### DEVELOPMENT REVIEW BOARD--SPEED MEMO

DRB CASE NO/PROJECT NO: 1006939

**RE: Tract 1, Brunacini Industrial Park/sketch**

PLAT OF
TRACTS 1-A THRU 1-D
BRUNACINI INDUSTRIAL
PARK UNIT III

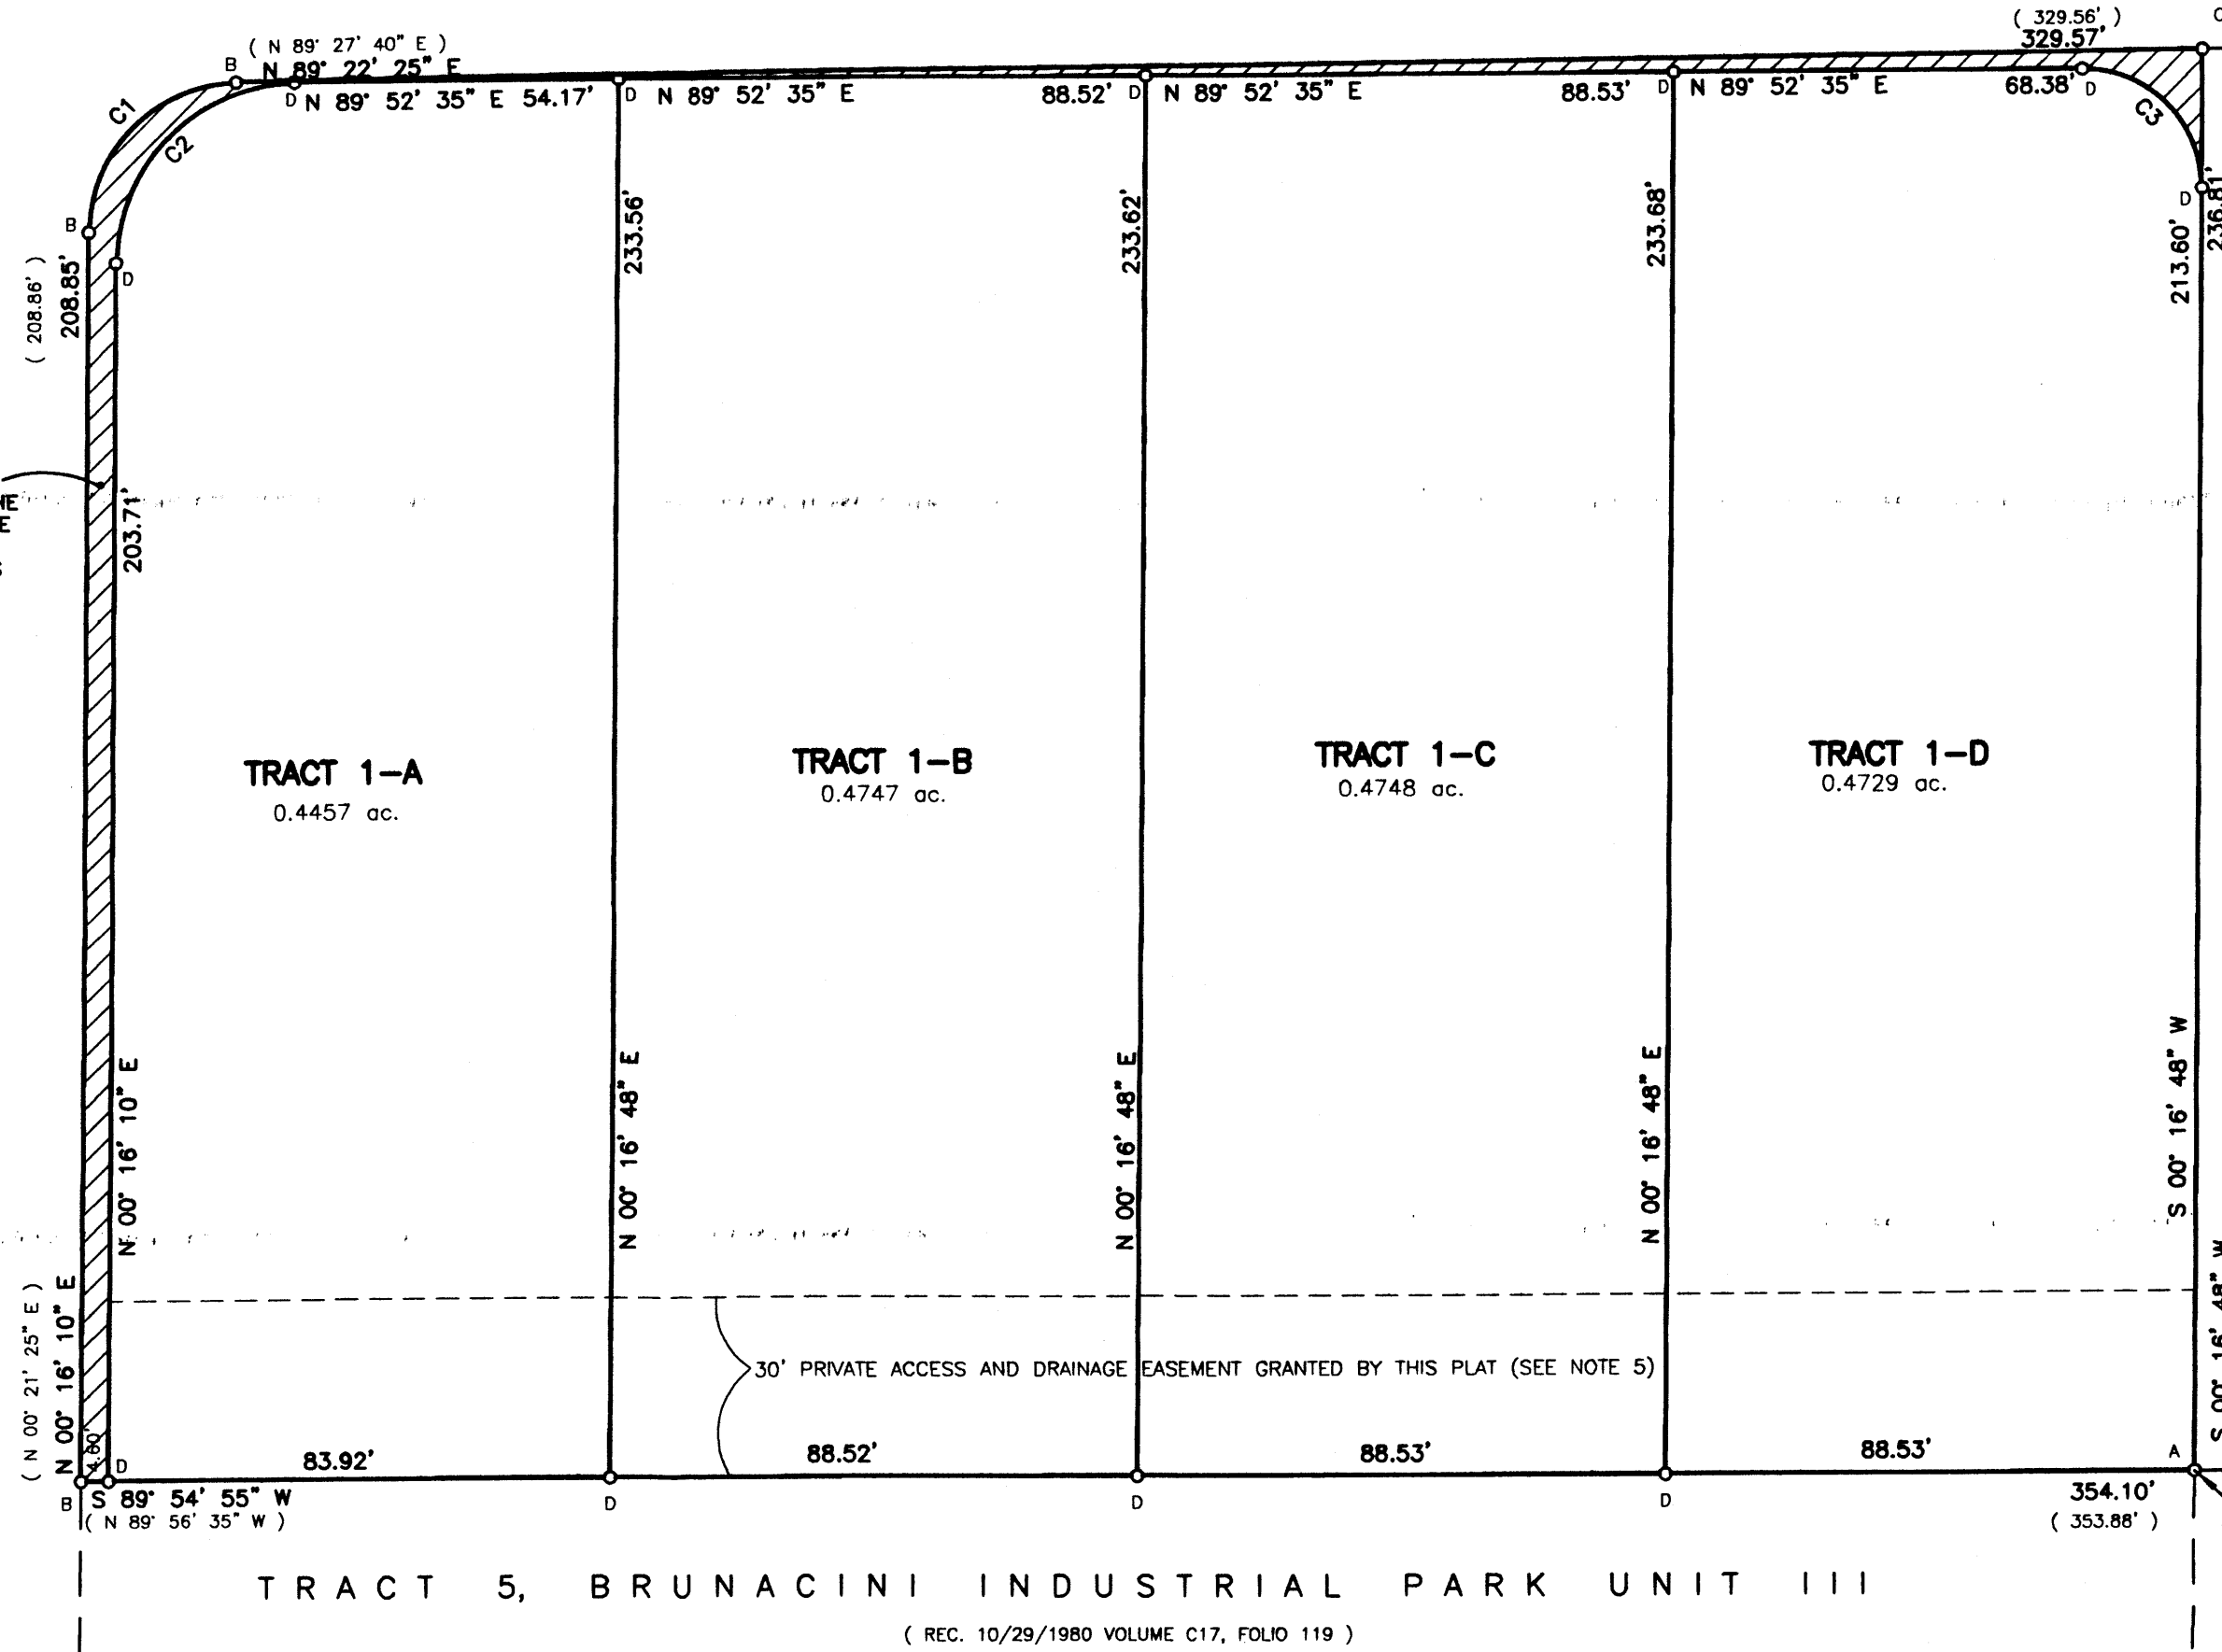
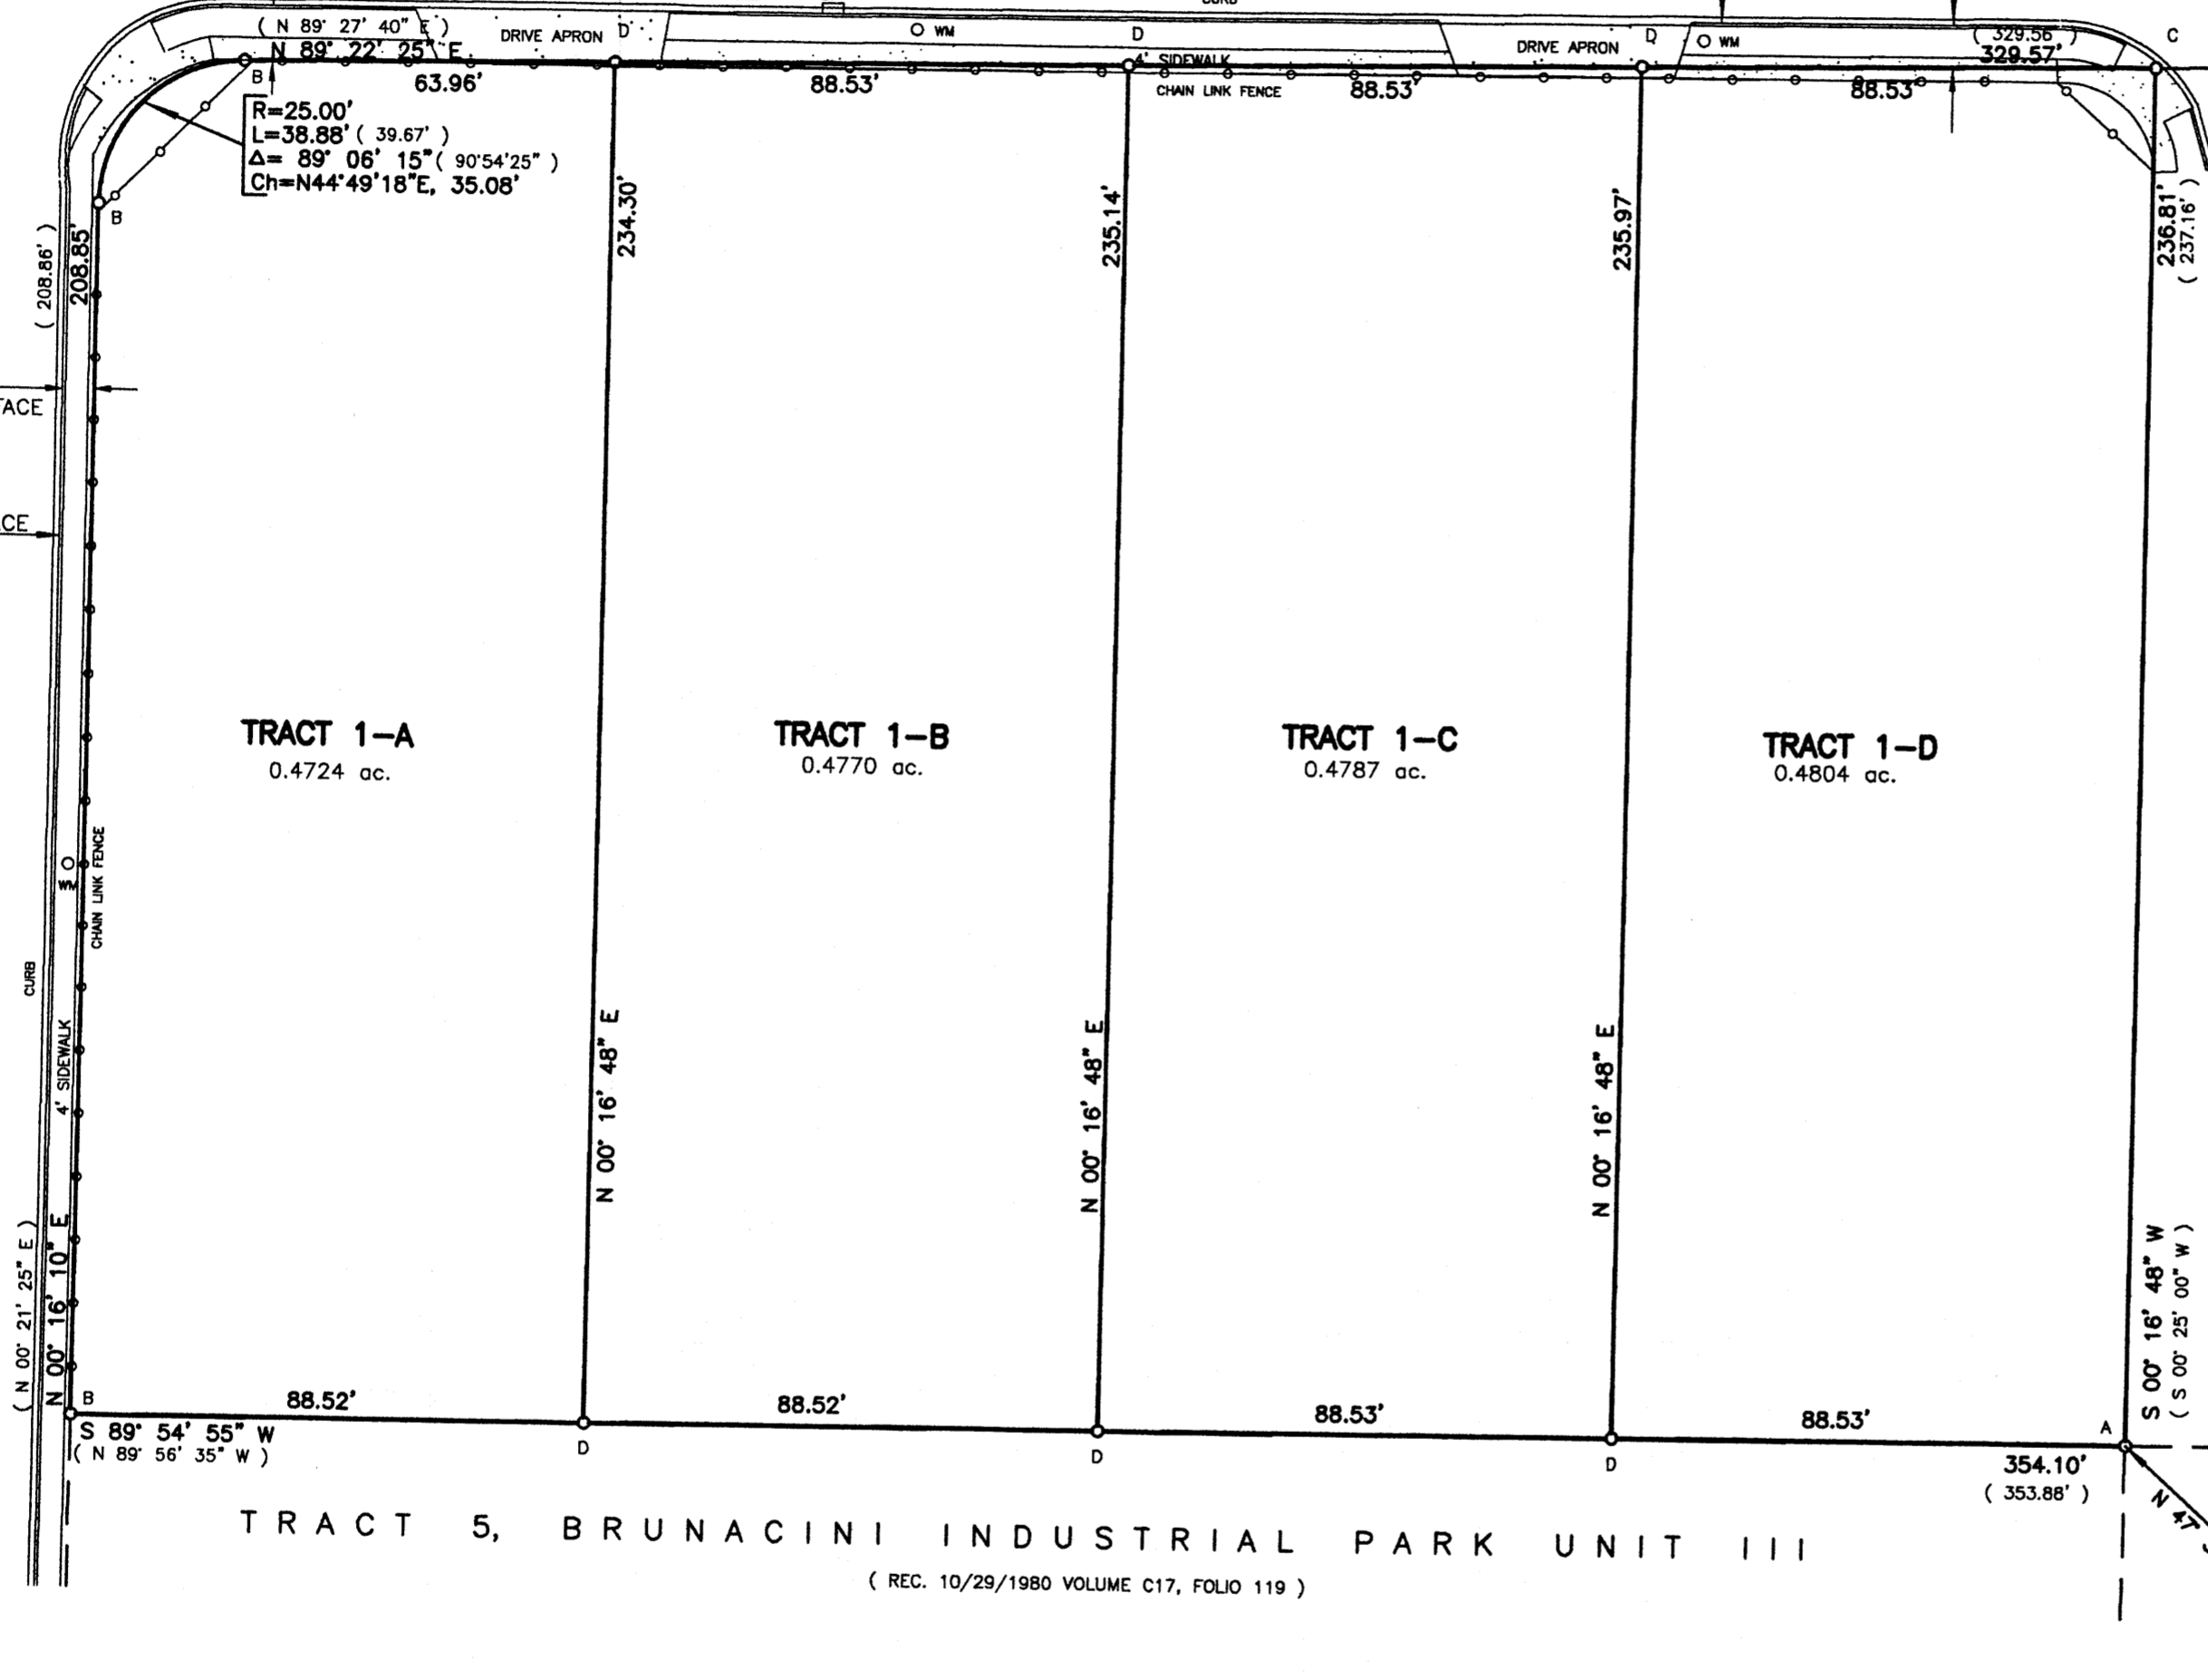
Need cross-lot drainage easement.
